Response to ExA's Second Written Questions (WQ2) – Q2.11.2.1

This document sets out the response to the Examining Authority (ExA)'s Second Written Questions (WQ2) Q2.11.2.1 by Cambridgeshire County Council (CCC), Huntingdonshire District Council (HDC) and South Cambridgeshire District Council (SCDC) (together, the Councils).

Q2.11.2.1: Road design and layout

**Figure 2: Current Proposal - Offline design of B1046 and Potton Road Realignment**

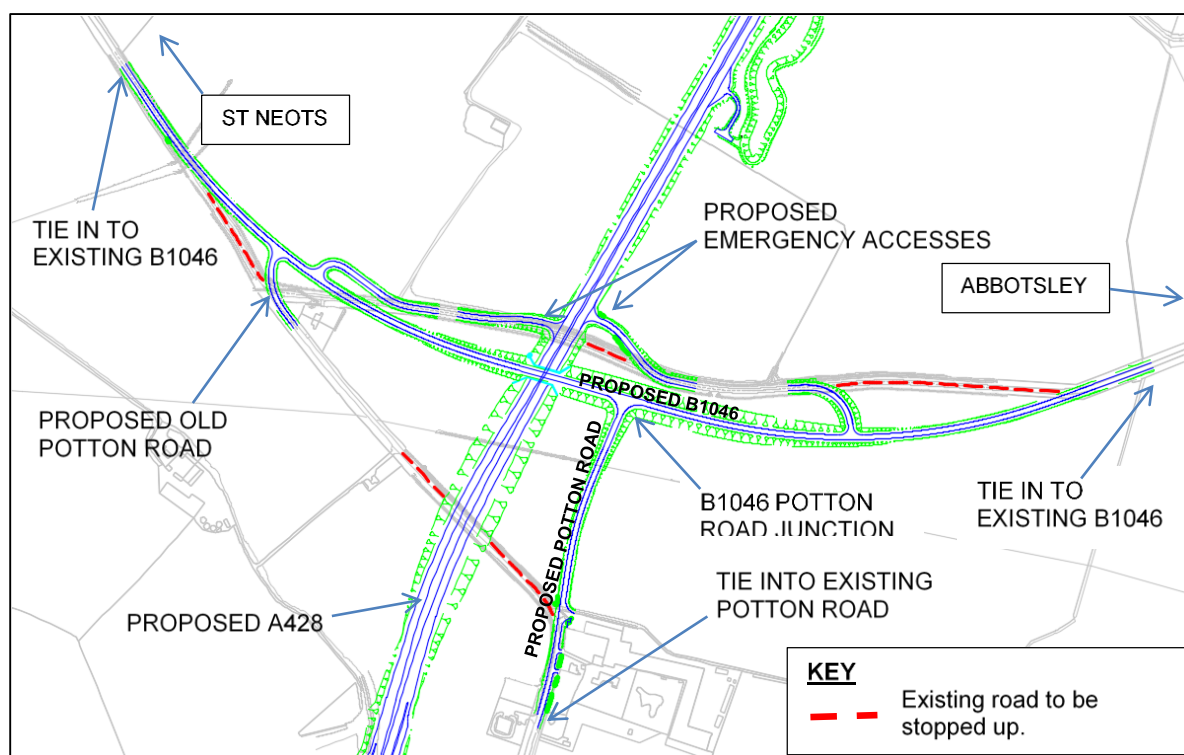
4.7. B1046 and Potton Road:

- The total length of proposed road is approximately 2km, with a compliant design requiring only one change in carriageway width at each tie-in, so there will not be numerous changes in cross section.

- From the western tie-in point on the B1046 travelling North, the existing road is straight for a distance of approximately 600m. There is then a curve in the road at the ECML bridge, after which the B1046 again continues in a straight line for a distance of approximately 600m into St. Neots

- From the eastern tie-in point on the B1046 travelling East the existing road is straight for a distance of approximately 300m. There are then two bends within 300m after which the B1046 continues East in an essentially straight line for a distance of approximately 2km to Abbotsley.

- In terms of the connection from the improved section to the existing the requirements of CD 109 ".....providing a similar standard of curvature and stopping sight distance..." are met.

- Collision data provides no evidence to suggest that the National Speed Limit of 60mph is unsafe.
